Reference: 24168-RGB-ZZ-XX-CO-ST-0003-SJ: DA 251031

RE: STRUCTURAL DESIGN CHANGE – CAR PARK WALLS PUSHED OUT FROM PREVIOUS SSDA LAYOUT

In this letter we wish to provide a technically grounded summary of the structural modifications captured in Figures 1 and 3 (original SSDA layout) and Figures 2 and 4 (revised layout).

Sheet title  
CARPARK LEVEL 05

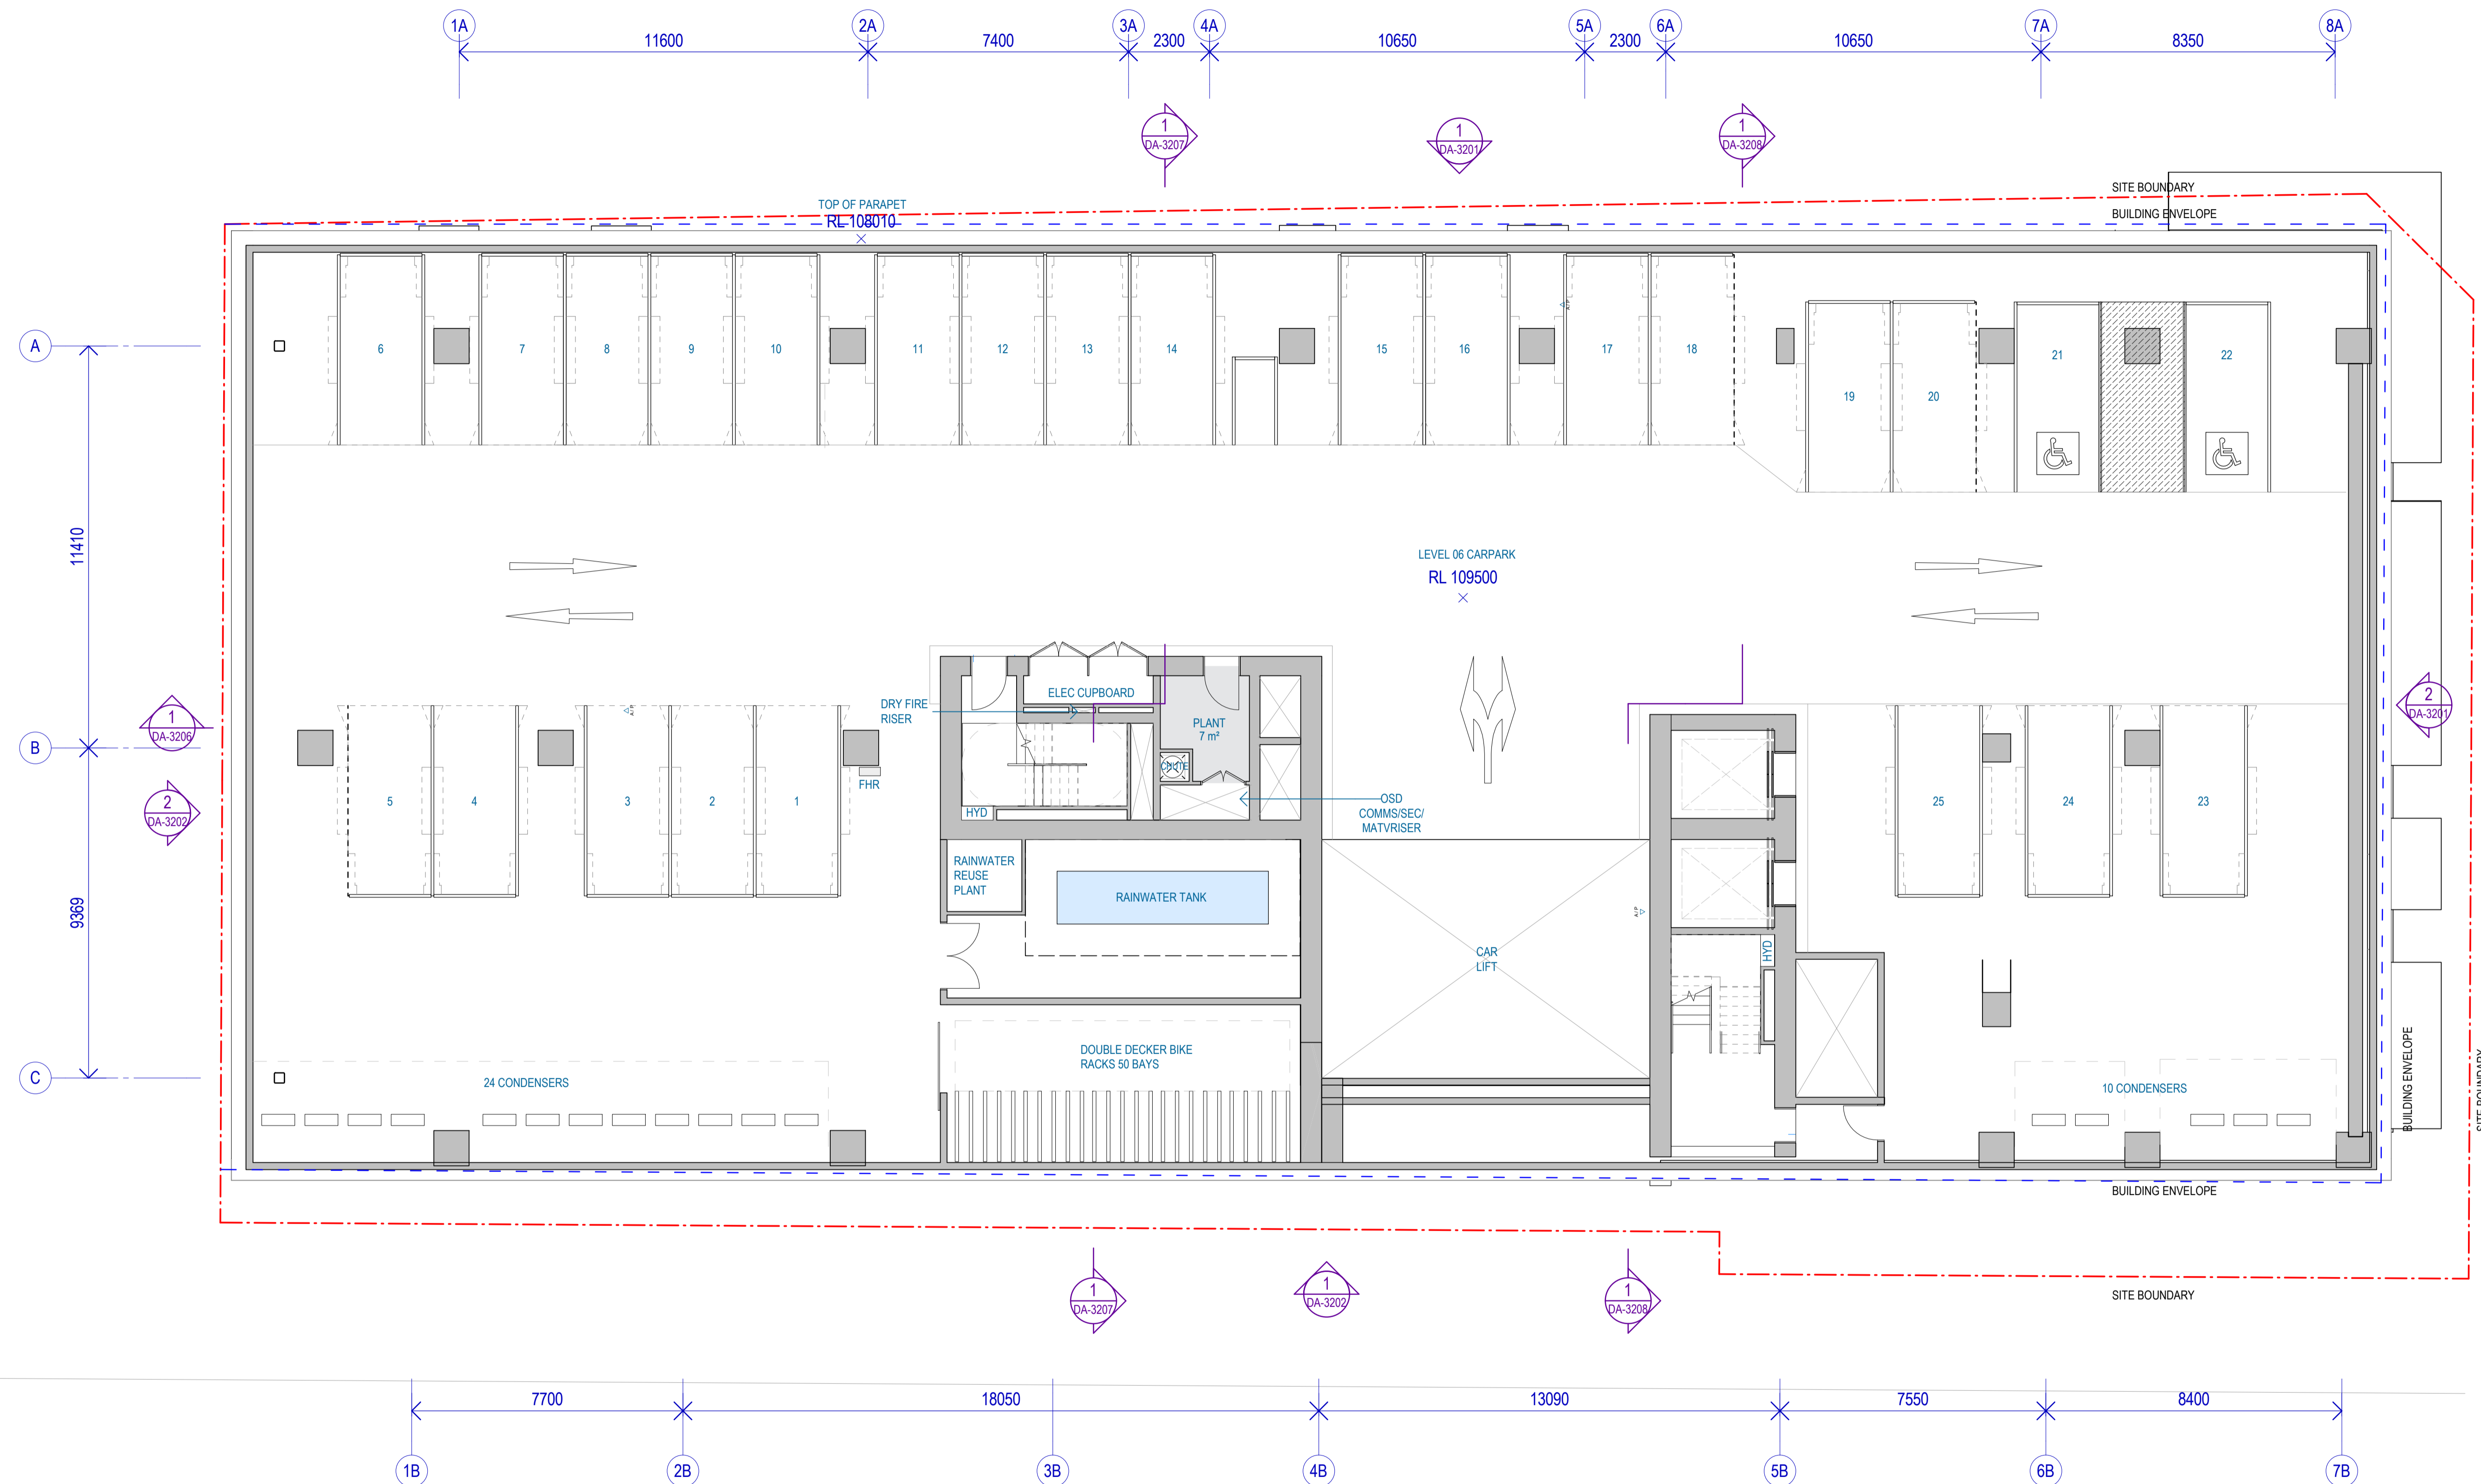
- As the structural design has developed from concept phase into a more detailed design, we have identified crucial structural requirements, necessitating alteration of the originally approved SSDA layout (Fig. 1 → Fig. 2 and Fig. 3 → Fig. 4).
- In summary, the perimeter car park walls have been moved outward on Clark Lane to align with newly added perimeter columns. The perimeter car park walls have also been moved outward on Pacific Highway to control mid-span slab deflections and on Level 06 and 07. A transfer wall has been added between Level 05 and Level 07 on the Hume Street elevation to support Level 08 transfer slab.
- These modifications ensure the structural integrity of the over station development while protecting the metro infrastructure below. The structural rationale for the proposed changes is discussed at length in Section 2, 3, and 4.

- With the carpark wall relocation, new perimeter columns now directly support loads from the underside of the Level 08 transfer slab and beams.
- Without extending the columns on the perimeter wall vertically, there would be discontinuities in the load path, resulting in unsupported cantilevers and inefficient load transfer.
- Extending columns upward restores continuity, ensuring loads from Level 08 are effectively transmitted down through the structural system to the foundation.

- A transfer wall has been provided along the Hume St side of the carpark to support loads from the Level 08 transfer slab and beams. The 400 thick transfer wall will extend down from Level 07 to Level 05.
- Similarly, without providing this transfer wall on Hume St, there would be discontinuities in the load path. Providing this transfer wall restores continuity, ensuring loads from Level 08 are effectively transmitted down through the structural system to the foundation.

- The originally proposed landscape buffer along the perimeter will need to be revised as it conflicts with the repositioned column layout, provision of the transfer wall, and extended Level 6 and 7 slab cantilevers.
- Keeping the landscaped zone as per the original SSDA would impede proper placement of structural columns and the transfer wall and could compromise the support of the transfer slab.
- Consequently, the landscaping zones must be reduced to maintain structural integrity and compliance with relevant building standards.
- The originally proposed landscape buffer along Hume St is no longer feasible due to the provision of the transfer wall in the same location.

- With support from RPS, a portion of the landscaping areas can be reintroduced around the Level 05 carpark (not along Hume St) as per Figure 6. This is aimed to help compensate for the loss of landscaping zones due to the structural changes.
